Recommendation Report for Planning Permission for Works or Extension to a Dwelling

REF NO: FP/113/21/HH

LOCATION: 14 Davenport Road
Felpham
PO22 7JR

PROPOSAL: Hip to gable loft conversion with juliet balcony, alterations to fenestration/openings and external facade.

Dwg No. 21009-P-107-D

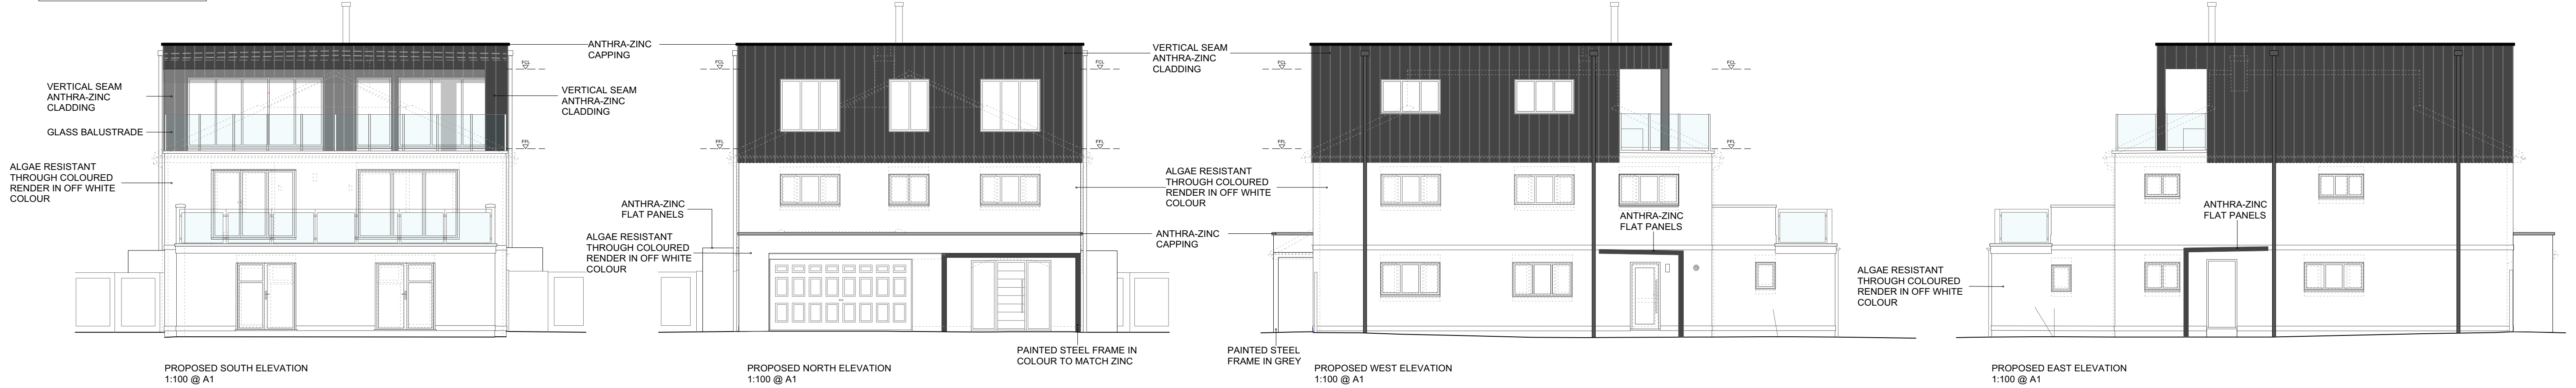
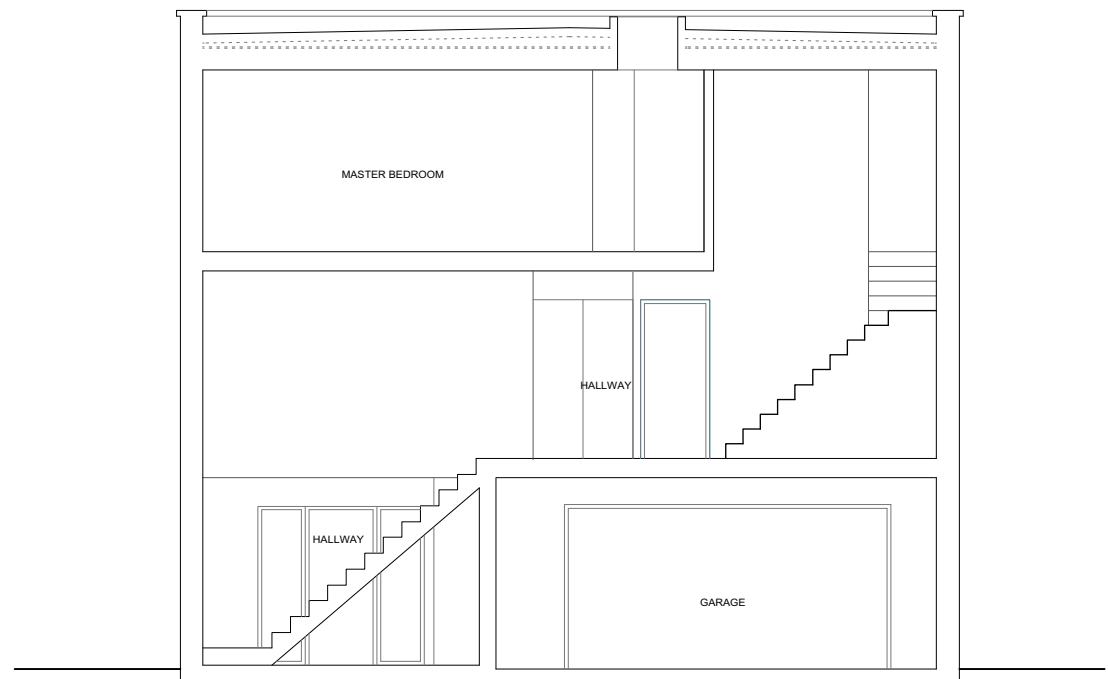
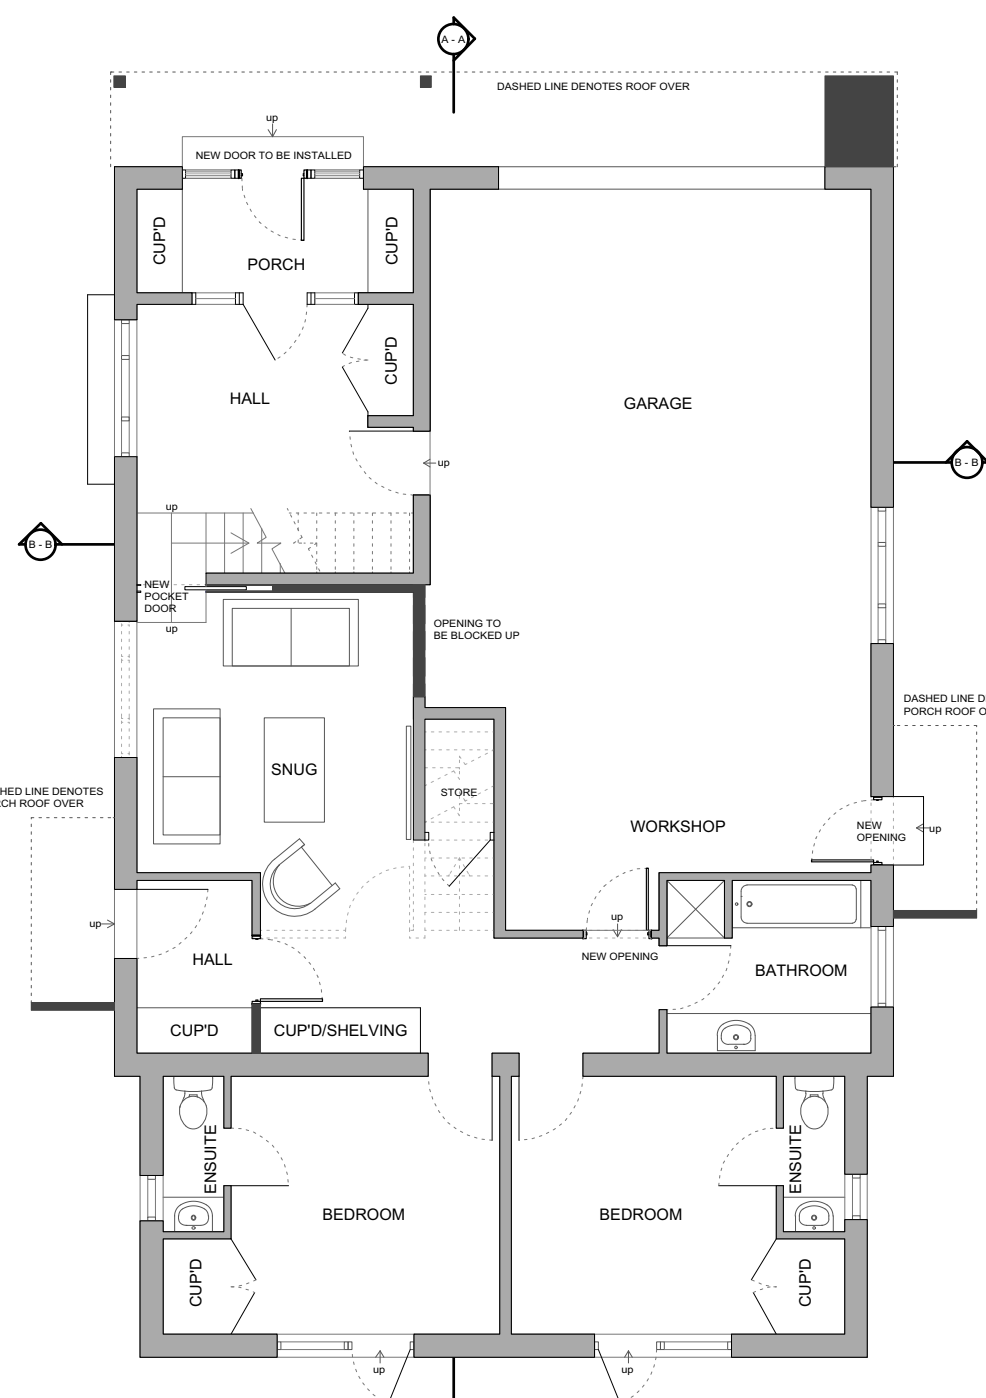
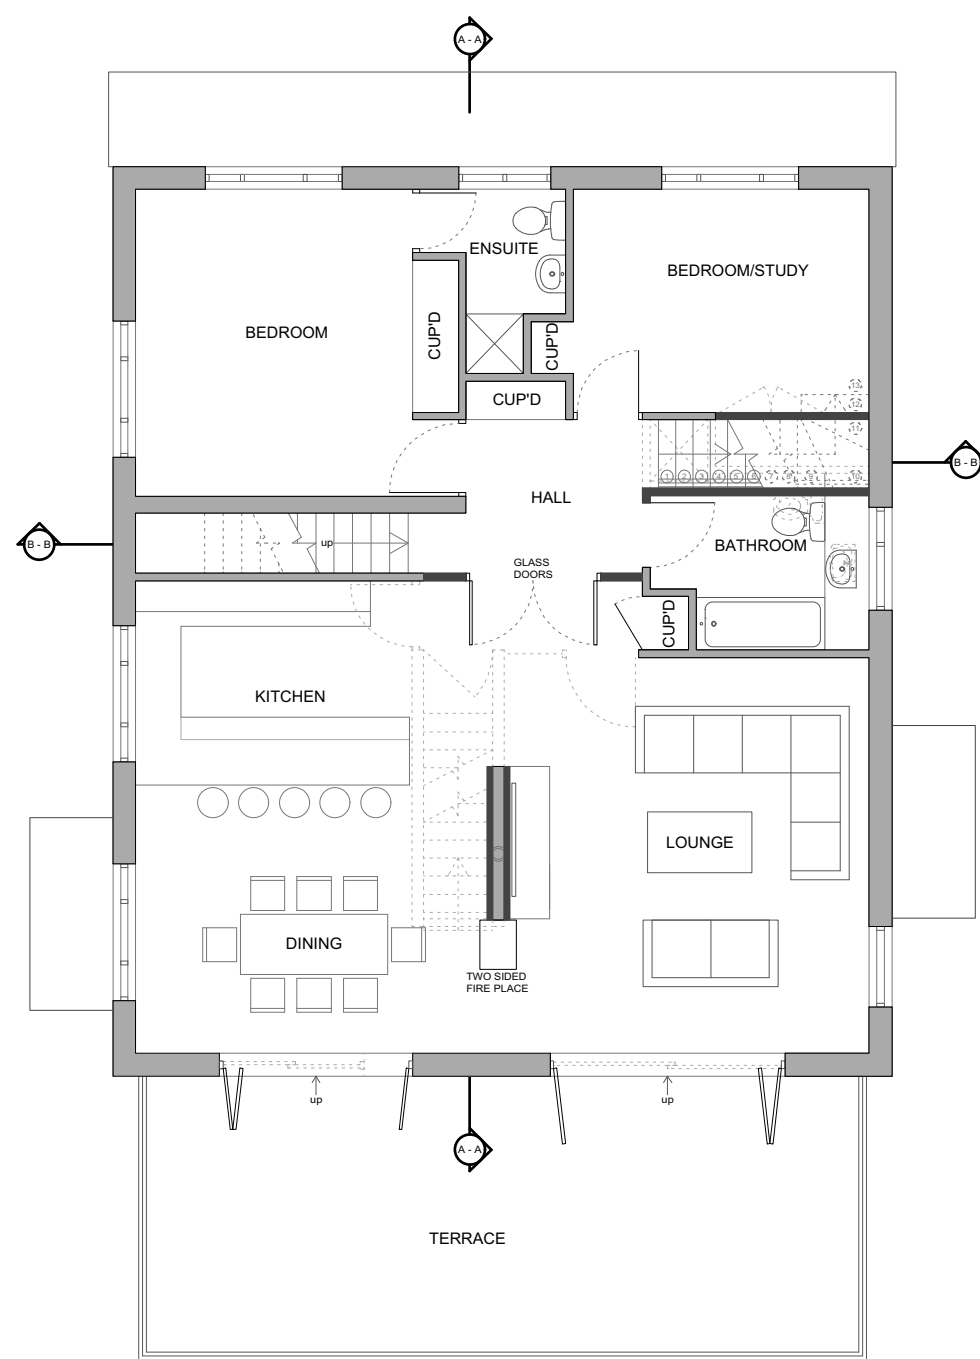
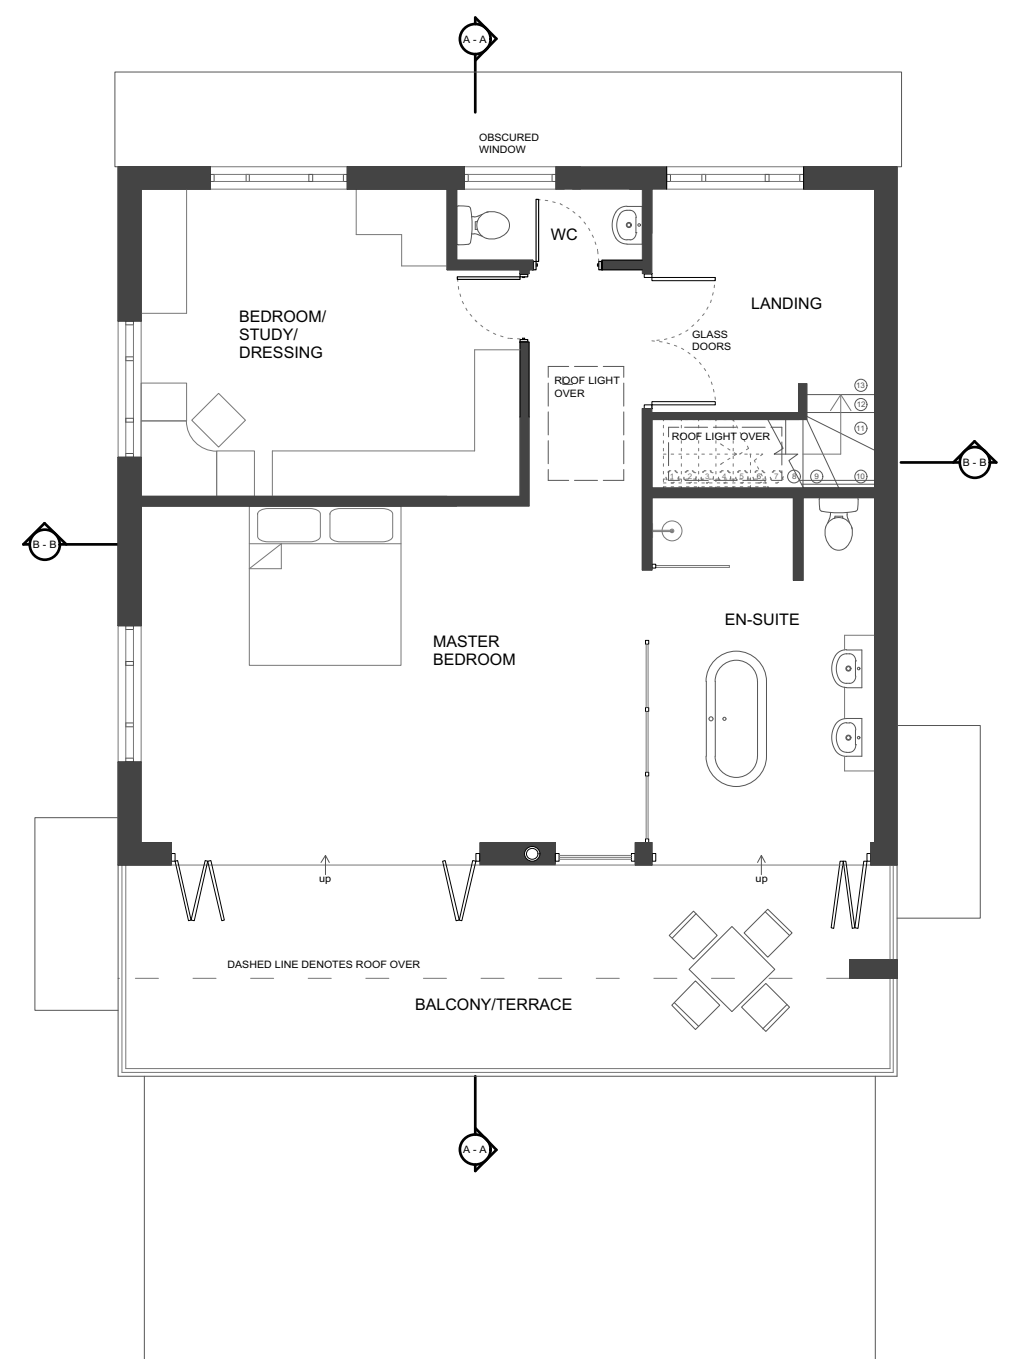
The side hip to gable extension of the west elevation has a proposed total roof length to 10.5m, due to the hip to gable roof change.

The Juliet balcony to the rear would not be out of character with the dwelling and would not dominate the appearance of the dwelling. There are multiple examples of terraces and balconies on Davenport Road allowing the proposal to be in keeping with the surrounding area and not an alien feature when looking at the rear from the seafront. The works will have views from all around with the additional floor creating a larger dwelling, however due to its design and location it does not have a demonstrably harmful impact

The second floor aspect due to the raising of the roof height cannot be considered subservient. There are examples of a variety of heights on the estate with neighbouring properties being higher. The addition proposes a height to match that of the neighbours on a spacious plot so is not considered to cause a precedent for taller dwellings.

Whilst the change in fenestration results in a change of appearance of the dwellinghouse due to the wide variety of different materials used for the external aspects of the surrounding properties. As such the addition of a new material is not considered to be to the detriment of the application.

Whilst the height of the property is to be increased, which will have some impact on the neighbours, the increase is not considered to be demonstrably harmful due to the varying heights of properties within the locality this is due to the existing highest point being 8m which will increase to 8.75m with the pitch height increasing by 0.75m. the design of the proposal with a flat roof allows the scheme to be acceptable, due to the height of the neighbouring properties being the same as that of the proposed.
